Our ref: Huntlee New Town - Stage 2 (SSD-70748466)

11 October 2024

Subject: Response to Submissions

ONRC-C03.11

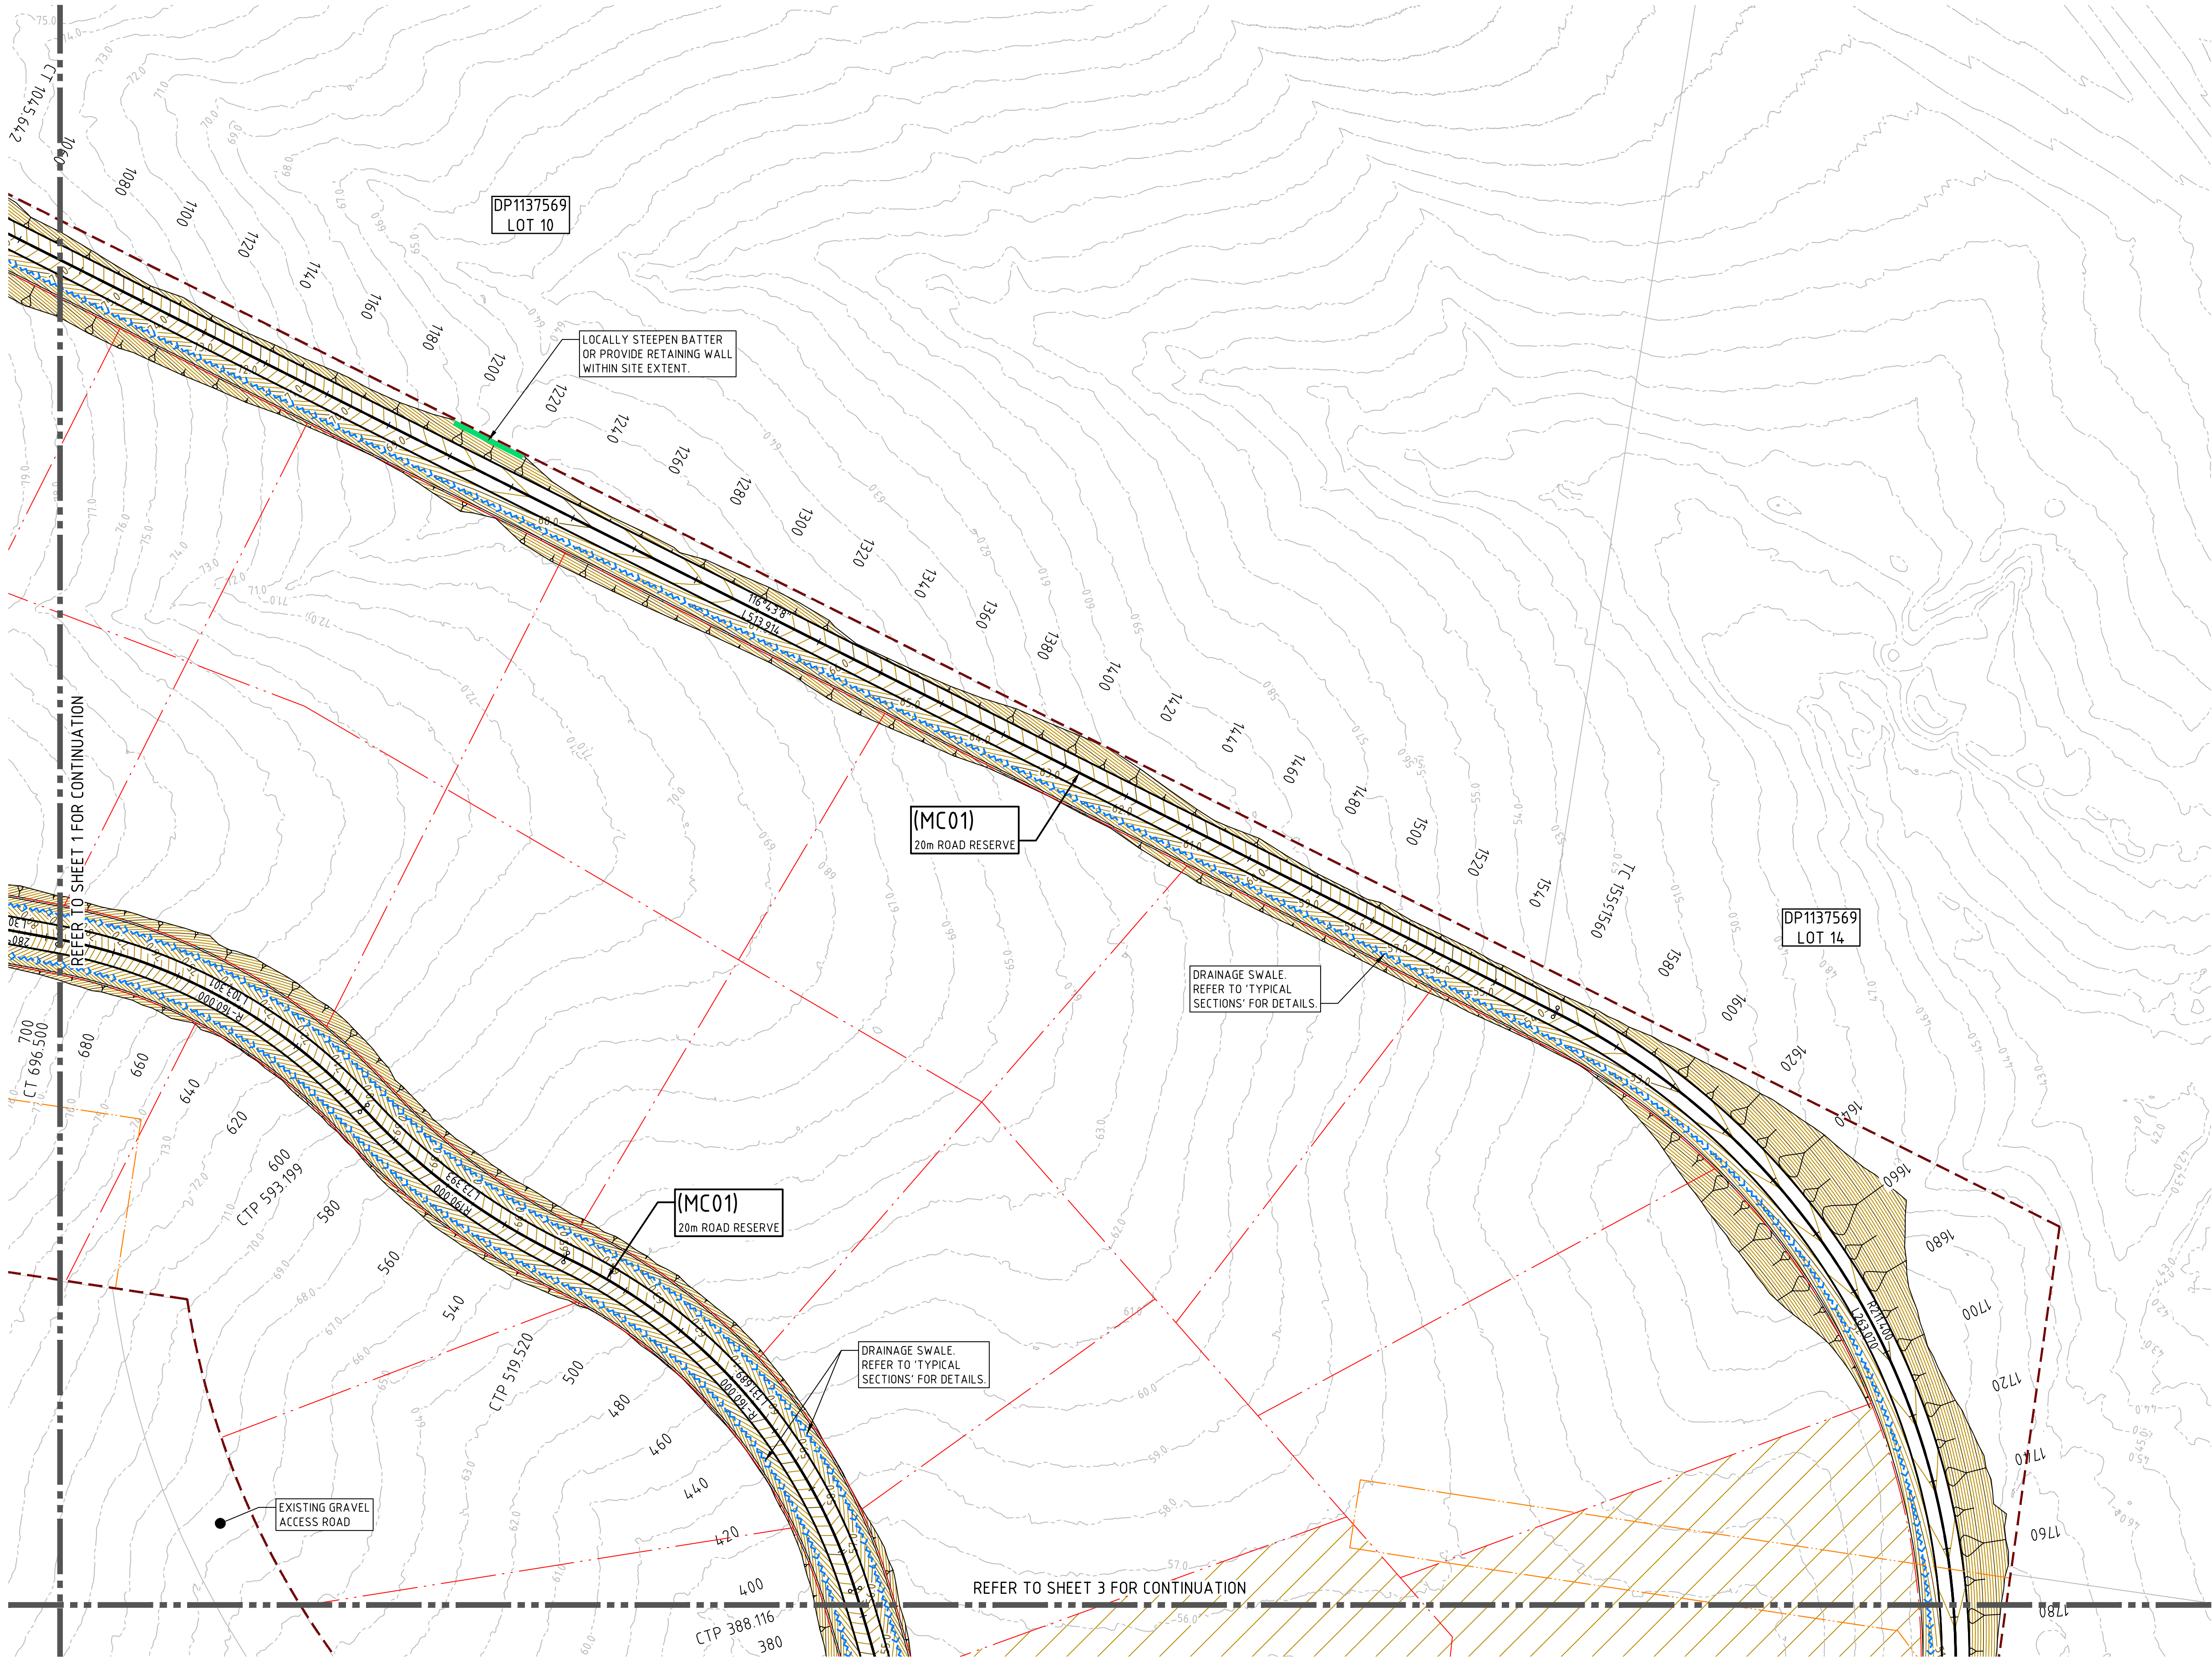
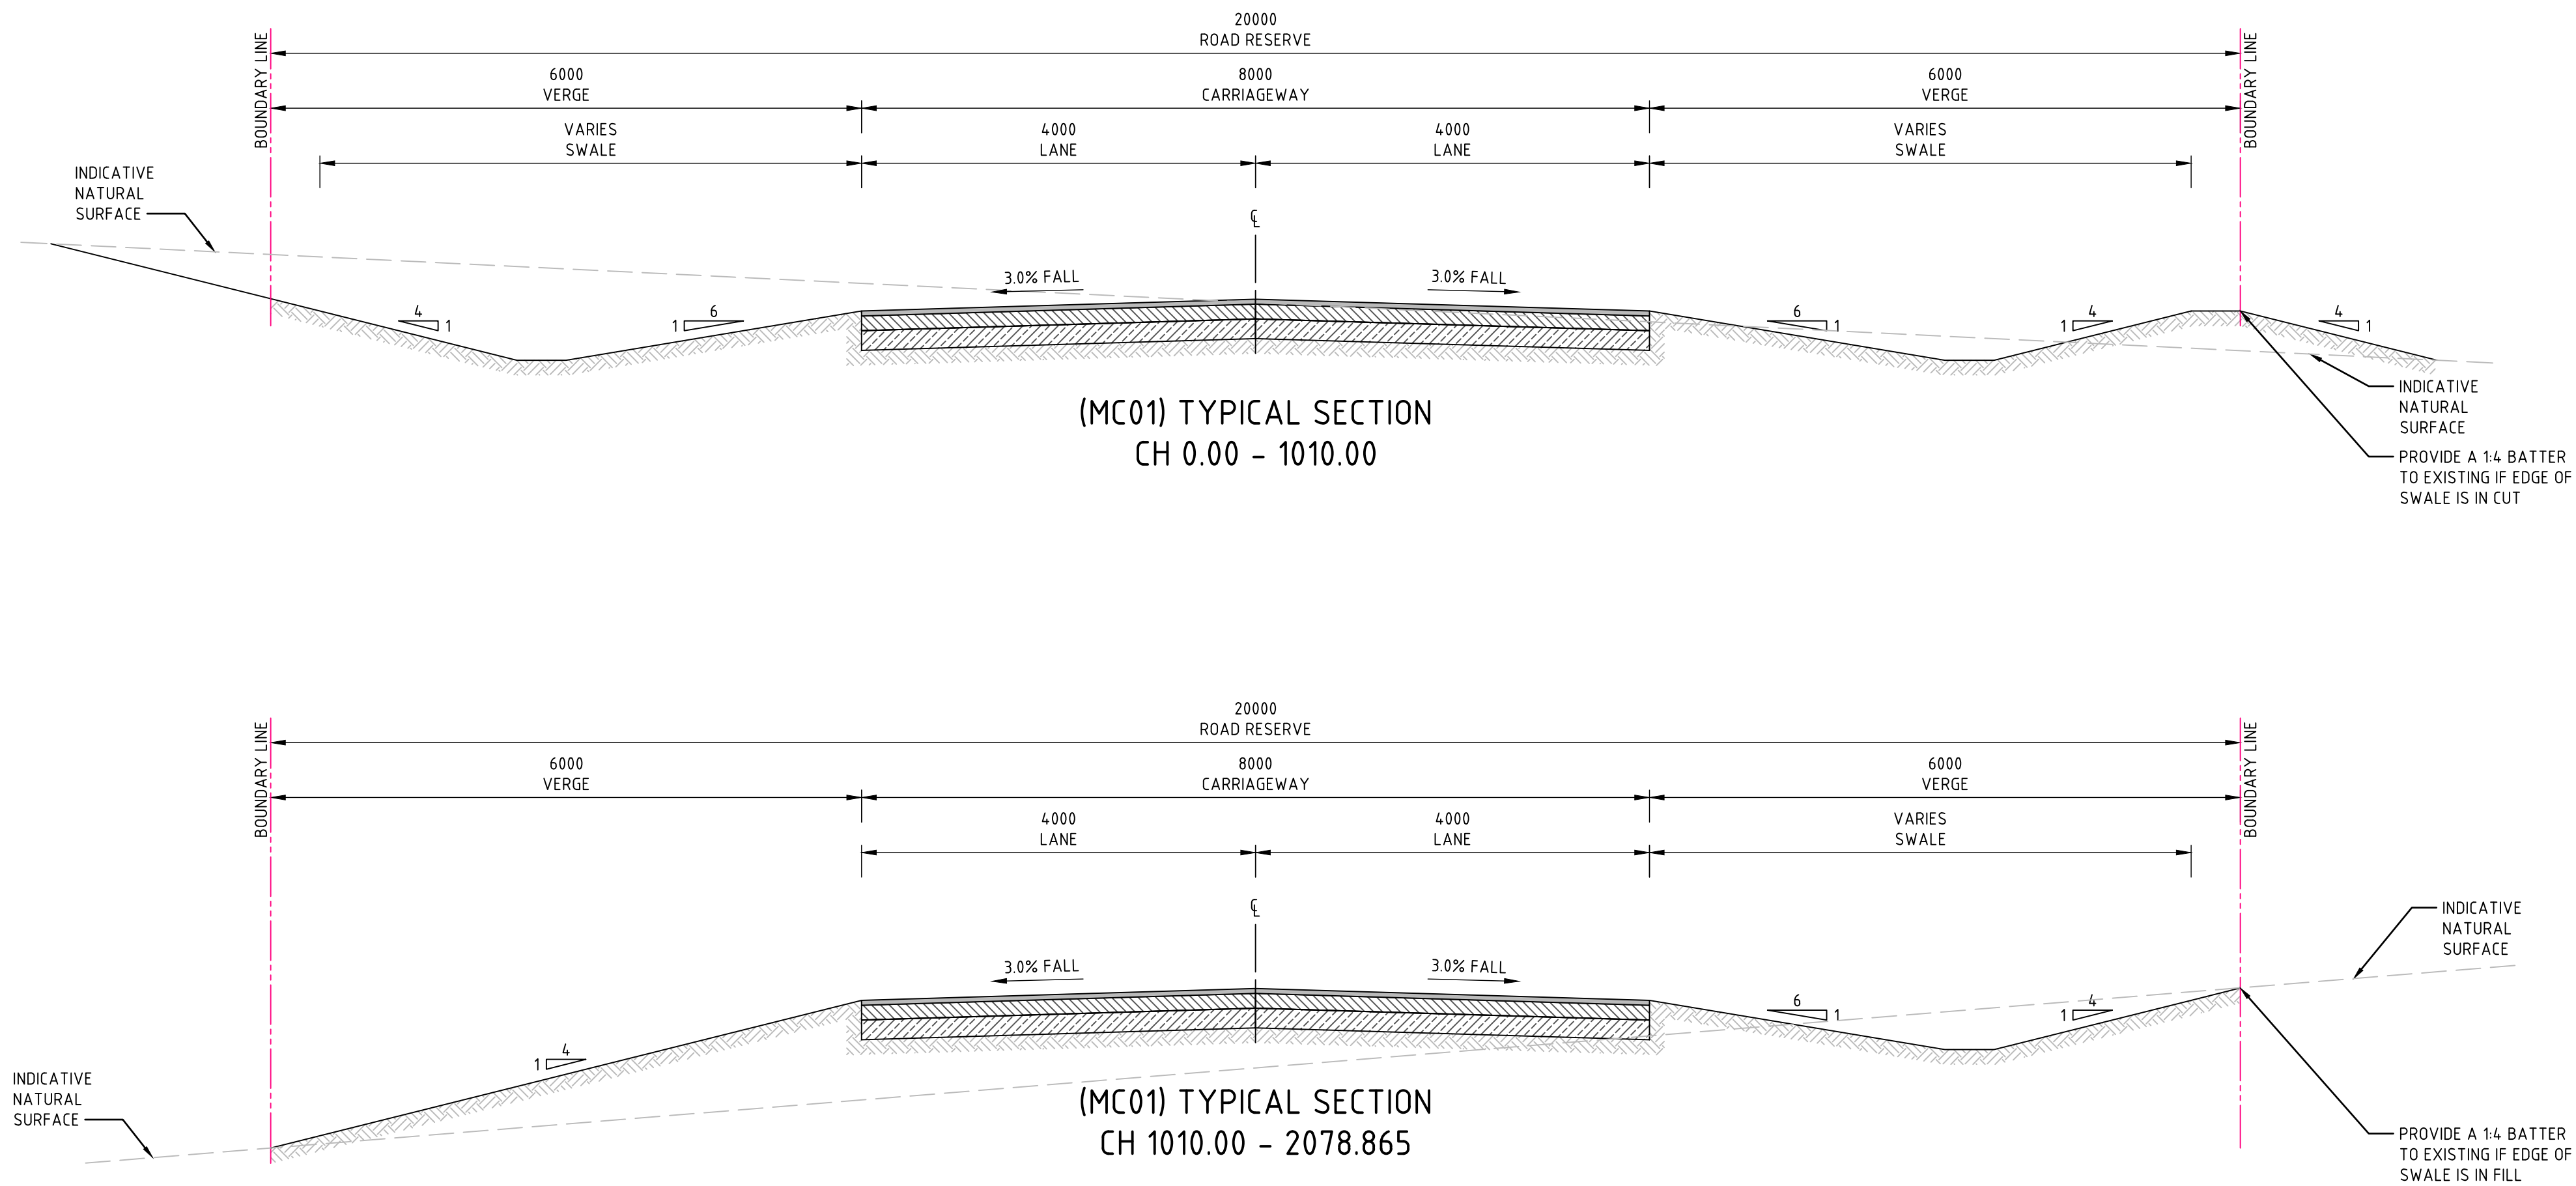
There are inconsistencies in the lot numbers and layout between the civil design plans and the subdivision plans.

- revised Civil Design Plans that have a consistent lot layout with the subdivision plans
